John Cockrell
119 Old Manor Road
Rustington
BN16 3QD

9 January 2021

Re: Planning Application R/234/20/HH
119 Old Manor Road, Rustington, BN16 3QD

119 Old Manor Road
 PROPOSED LAYOUT
 Scale: 1:50
 April 2020
 Drawing 2

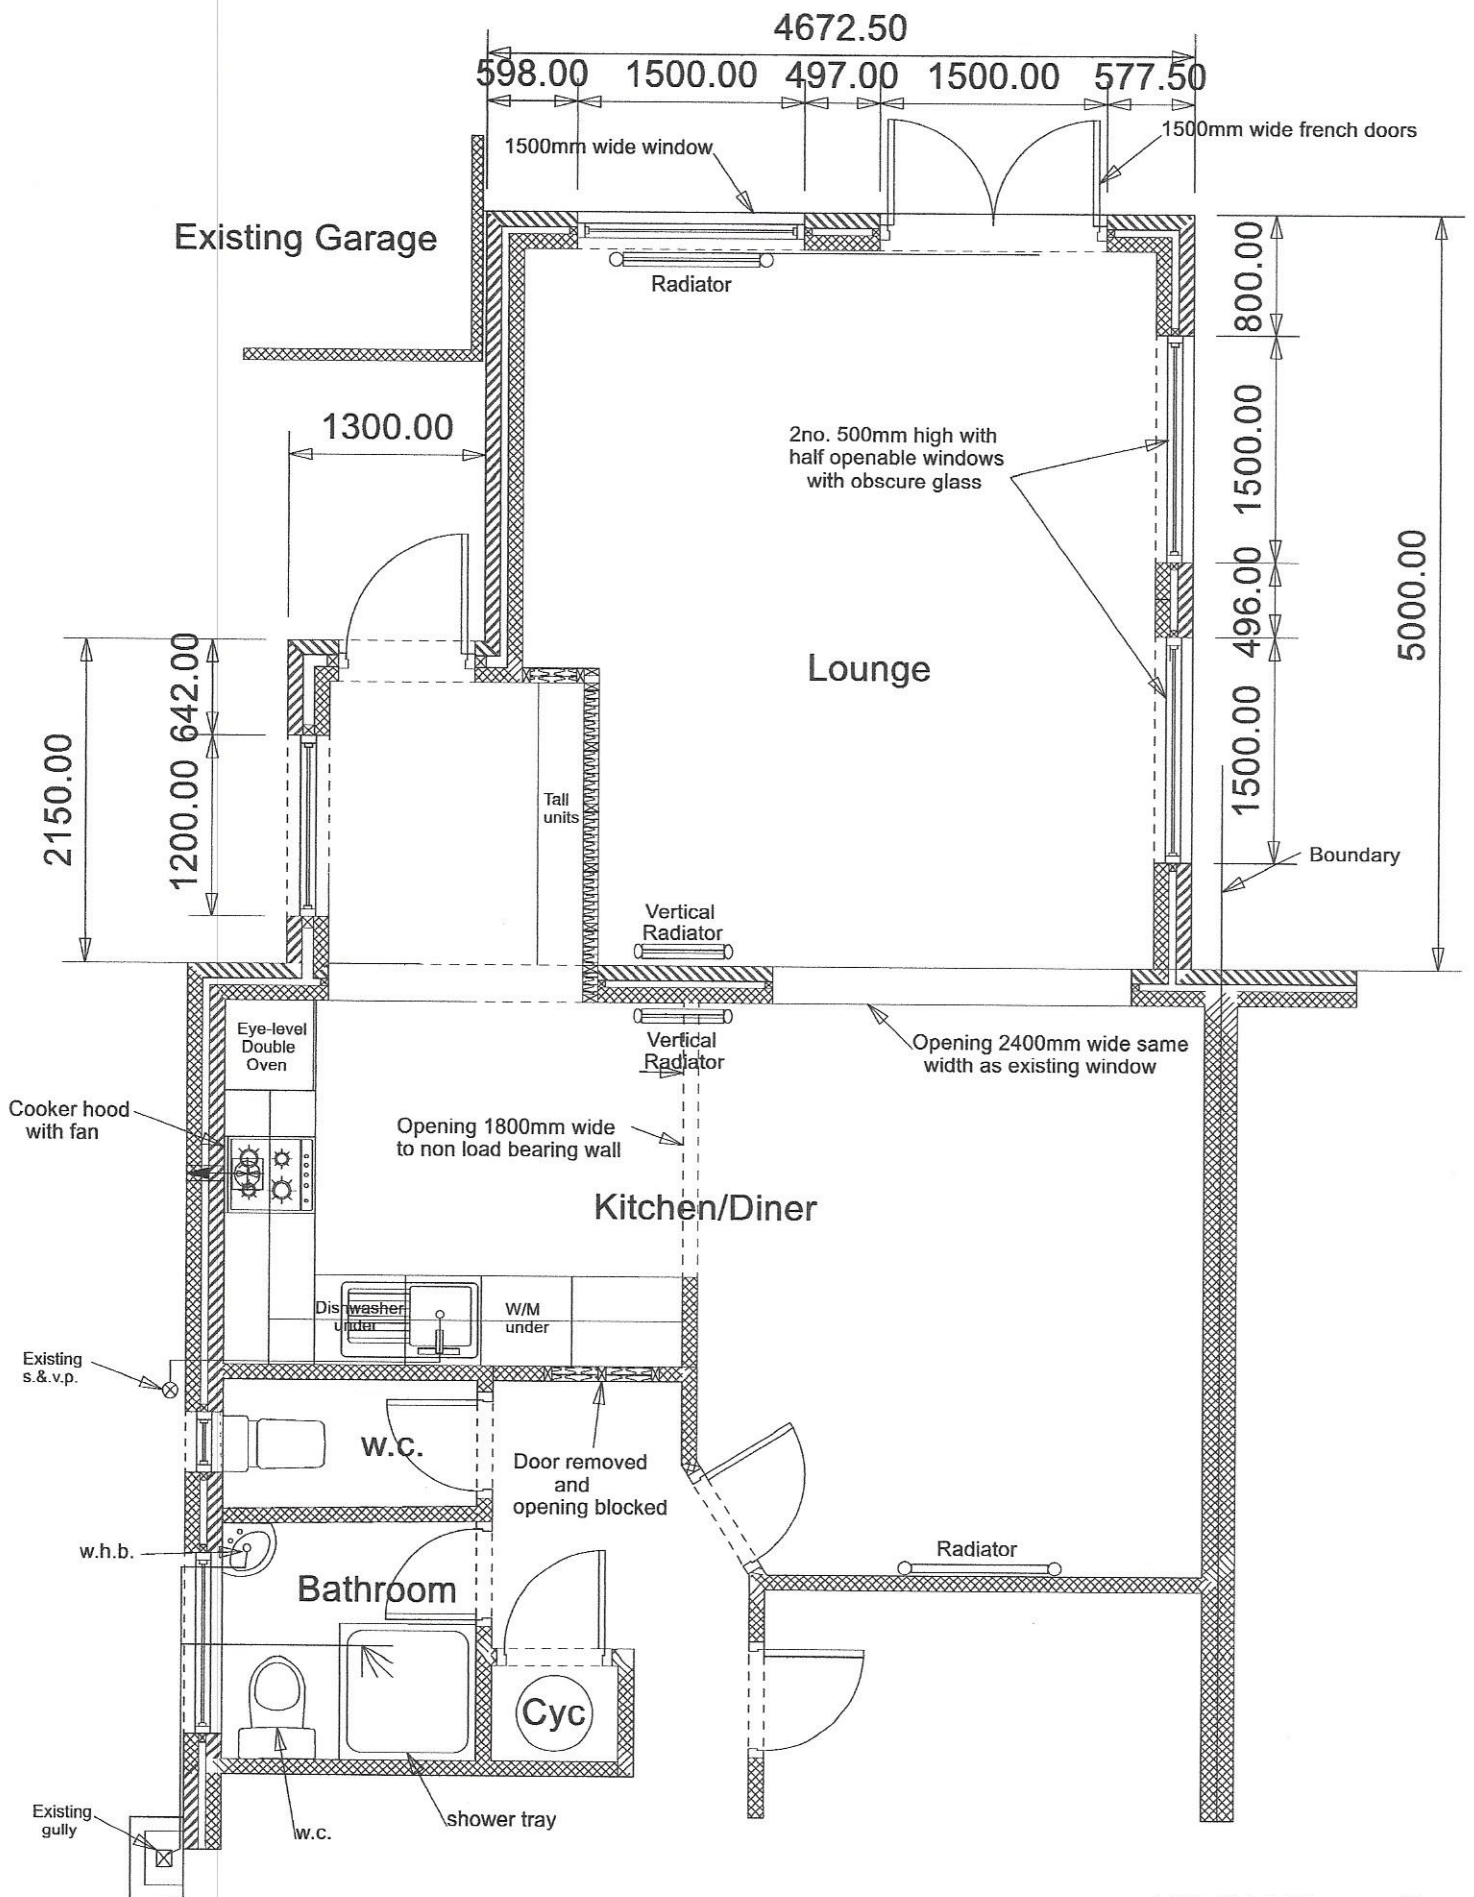
- The windows she is objecting to are both at high level with obscure glazing and originally were not going to be openable but were changed to half opening with 100mm restrictors due to insufficient openable area for the floor space. These windows have only been opened once when the plaster was working on a very hot day in July 2020 and since then have Not been opened.

119 Old Manor Road
REAR ELEVATION
Scale: 1:50
April 2020
Drawing 5

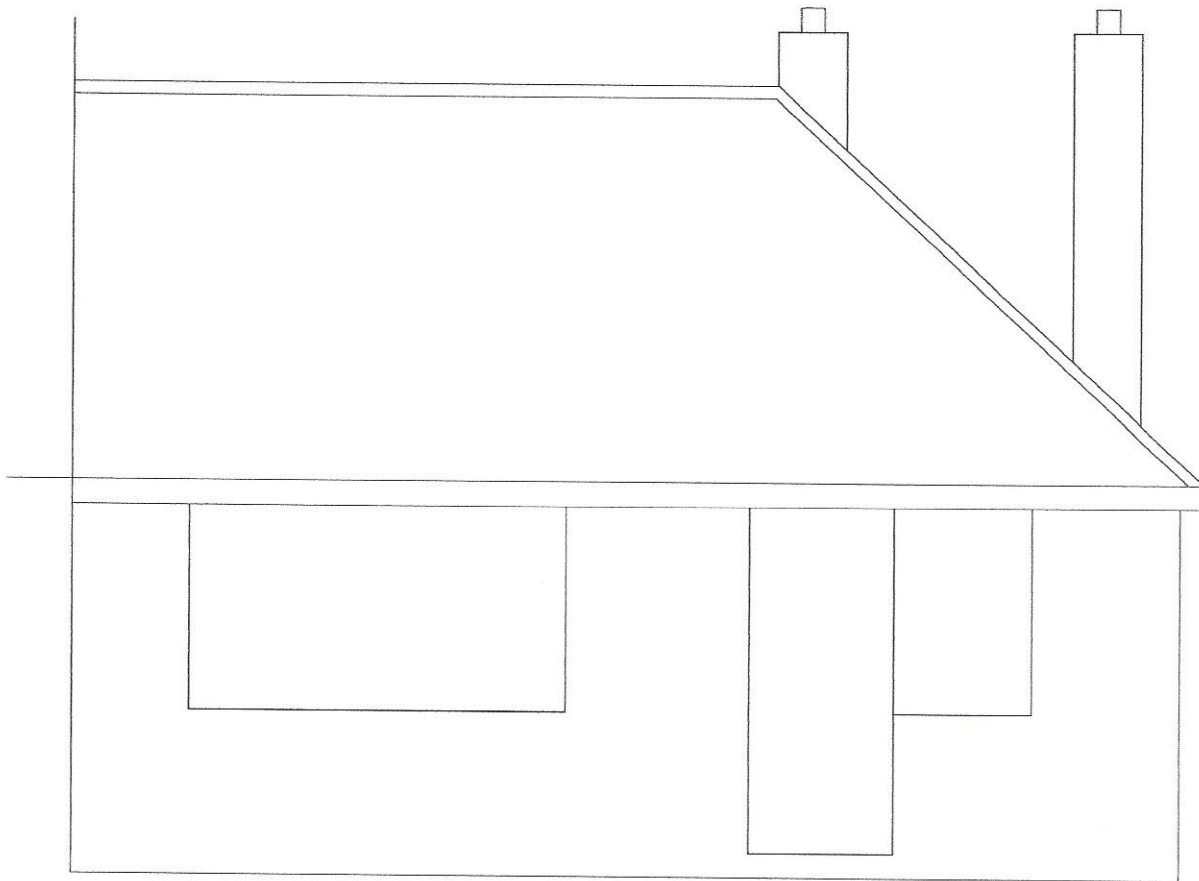
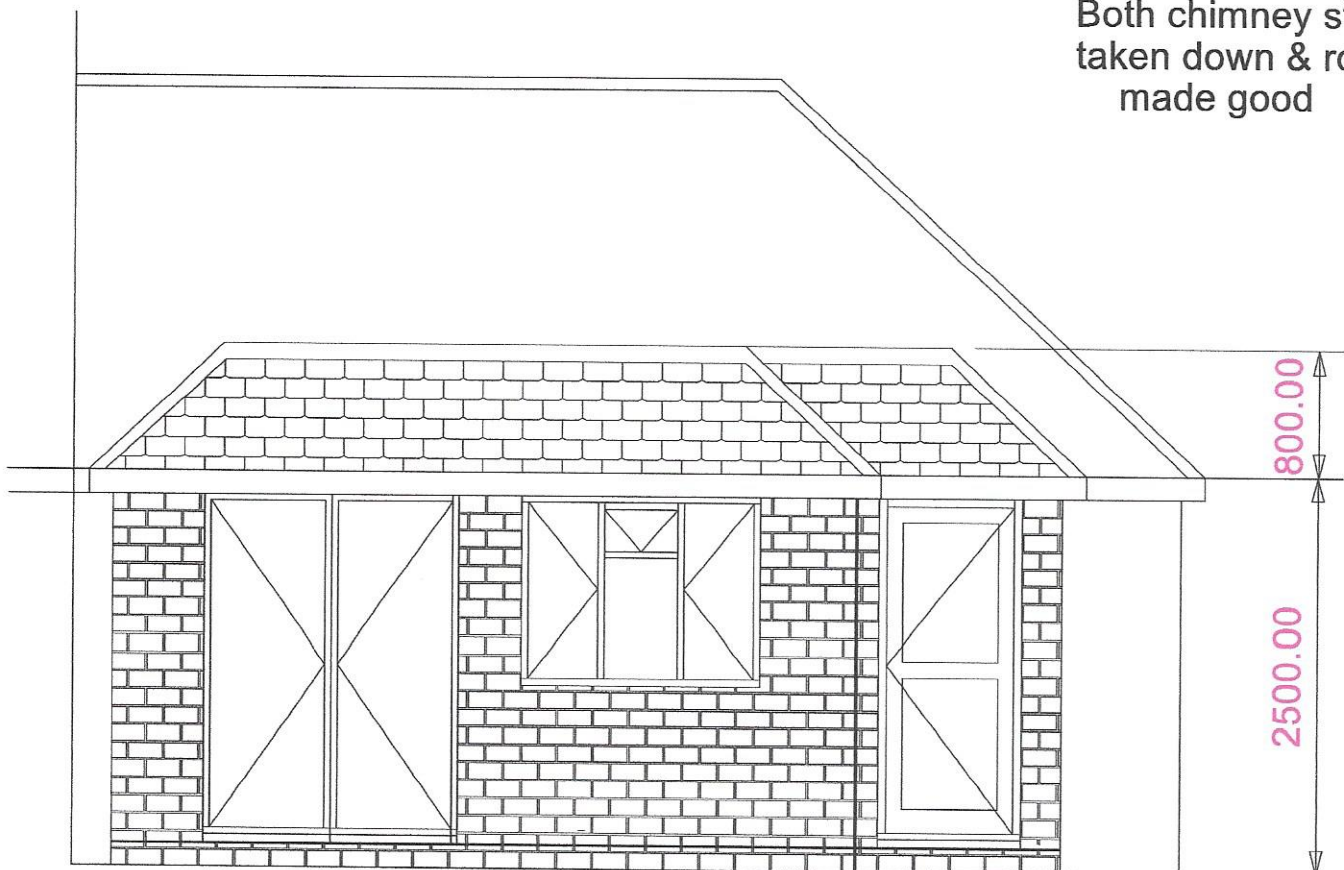
- With regard to the height this is because the roof has been designed as a 'Mock' pitched roof which is more in keeping than a straight forward flat roof.
-
